KITITITAS COUNTY COMMUNITY DEVELOPMENT SERVICES

November 24, 2008

Kittitas County Community Development Services has determined that the Galaxy Short Plat (SP-07-139) is a complete application and hereby grants *conditional preliminary approval* subject to the following conditions:

SHEET 1 OF 2

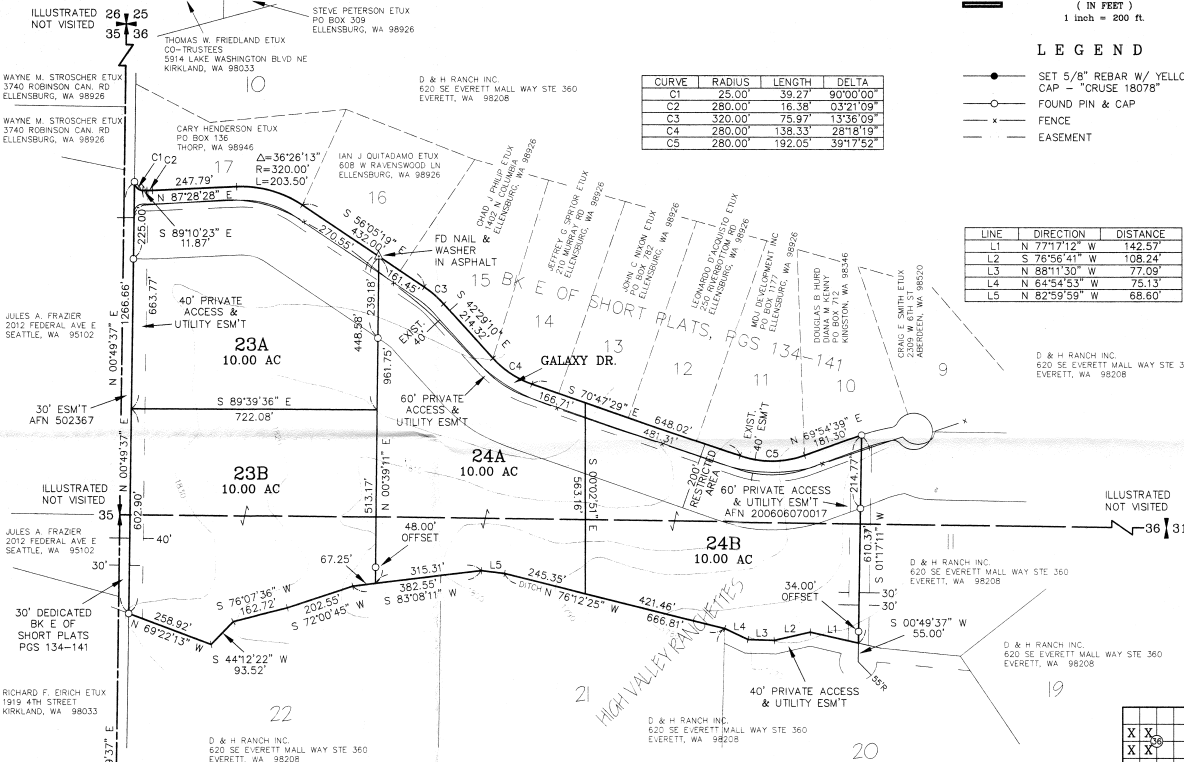
12. Road Name: Silverton Road shall be labeled and clearly shown on the plat.
13. Cul-de-Sac Construction and Right of Way: Per the conditions of the High Valley Ranchettes Plat Amendment P-07-57 and Resolution 2008-64, the applicant is required to construct a cul-de-sac at the end of Silverton Road and dedicate at least 110' diameter of right of way. Prior to final approval, the applicant shall consult with Public Works to determine the best location for the cul-de-sac and discuss details of construction.

15. Lot 23A, Lot 23B & Lot 22 Access: Lot 22 is also accessed from the 30' Easement. Until such time Lot 22 is accessed from a different easement, Lot 23A shall access from Galaxy Drive. If Lot 23A accesses from the 30' Easement, Low Density Private Road improvements will be required, including a cul-de-sac and additional easement.

16. Galaxy Drive Improvements: Galaxy Drive shall be constructed to meet or exceed the conditions of a Low-Density Private Road. See Kittitas County Road Standards, 9/6/05 edition.

- a. Access easements shall be a minimum of 60' wide. The roadway shall have a minimum width of 20', with 1' shoulders, for a total width of 22'.
 - b. Minimum centerline radius will be 60'.

- c. The surface requirement is for a minimum gravel surface depth of 6".
 - d. Maximum grade is 12%.
 - e. Stopping site distance, reference AASHTO.
 - f. Entering site distance, reference AASHTO.

17. Cul-de-Sac: A cul-de-sac turn-around having an outside right-of-way or easement diameter of at least 110 feet shall be constructed at the closed end of all dead-end roads serving 3 or more lots. The driving surface shall be at least 96 feet in diameter. Cul-de-sacs must also conform to the requirements specified by the 2006 International Fire Code. Contact the Fire Marshal regarding any additional cul-de-sac requirements.
